From: Scott Castle <[REDACTED]>
Sent: 23 August 2019 16:19
To: carol.reynolds@arun.gov.uk
Cc: Darren Godfrey
Subject: 22 Beach Road, Littlehampton.
Importance: High

I write further to the client providing me with your feedback on the AASL acoustic report dated 6th June 2019 for the above site.

Figure 4. Internal Measurement Positions

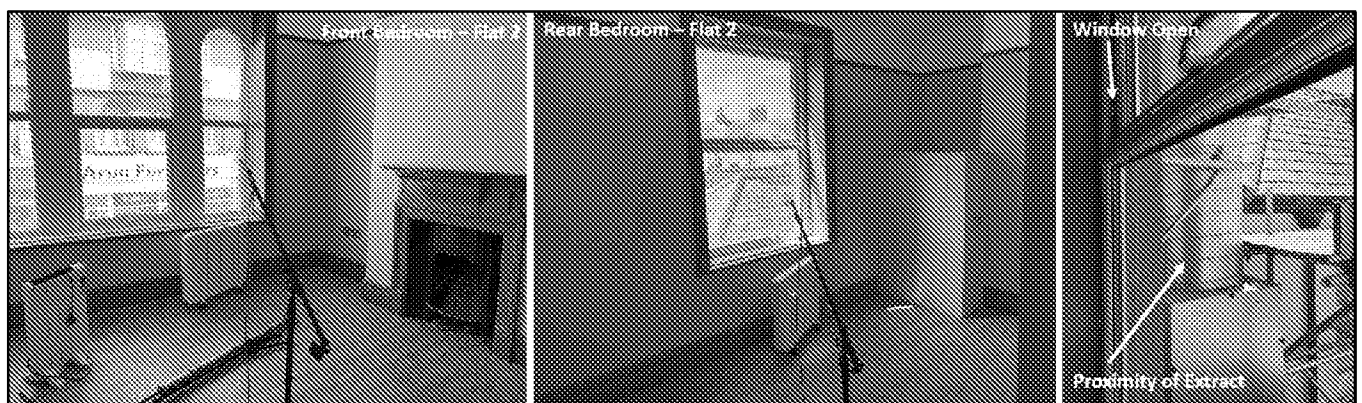
The reverberation times were measured in each of the locations where the surveys were undertaken. As noted from Table 3 in the report, the front bedroom in flat 2, was considerably higher in terms of reverberation than the smaller two bedrooms measured. As per Figure 4 of the report, the image displayed on the left hand side shows the laminated floor already laid.

When the bedroom is lived in and furnished with curtains, beds, pillows and duvets etc, the reverberation time will inevitably decrease and in this case a final reverberation time of 0.5s as was used in the calculations (This is what the Building Regulations state will be the average reverberation time for a furnished room). In this instance the correction used was 3dB as the empty surveyed rooms had an average reverberation time of 1s

Figure 4. Location of Condensers serving Walk in Chiller

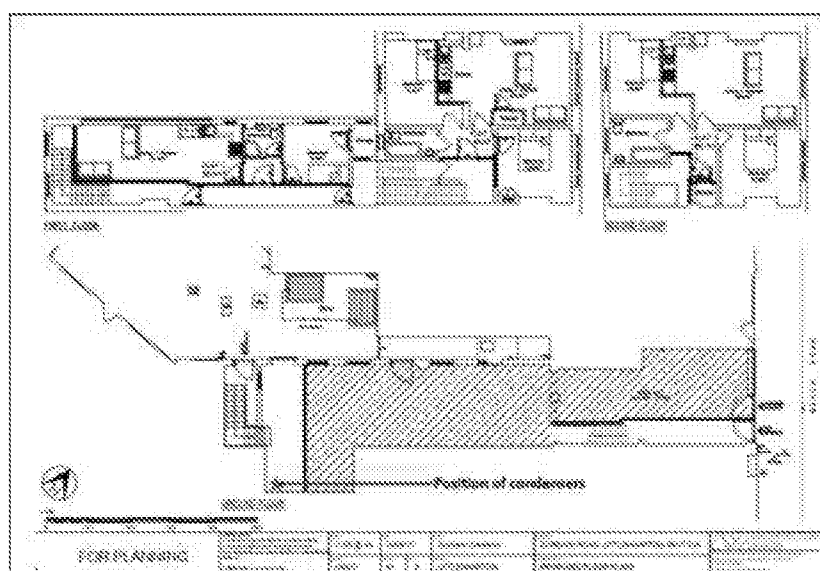
1. The condenser unit for the Walk in chiller.

The condensers were previously located below the bedroom window but have since been relocated to inside the rear garage unit at the very rear of Flat 1, outside the demise of the flat.

The condensers are mounted on anti-vibration mounts on the ground floor. Both the garage and the pizza hut ceiling were soundproofed at the same time. The condenser positions inside the garage void are shown below.

The condensers would have run as part of the survey and are contained with the survey data.
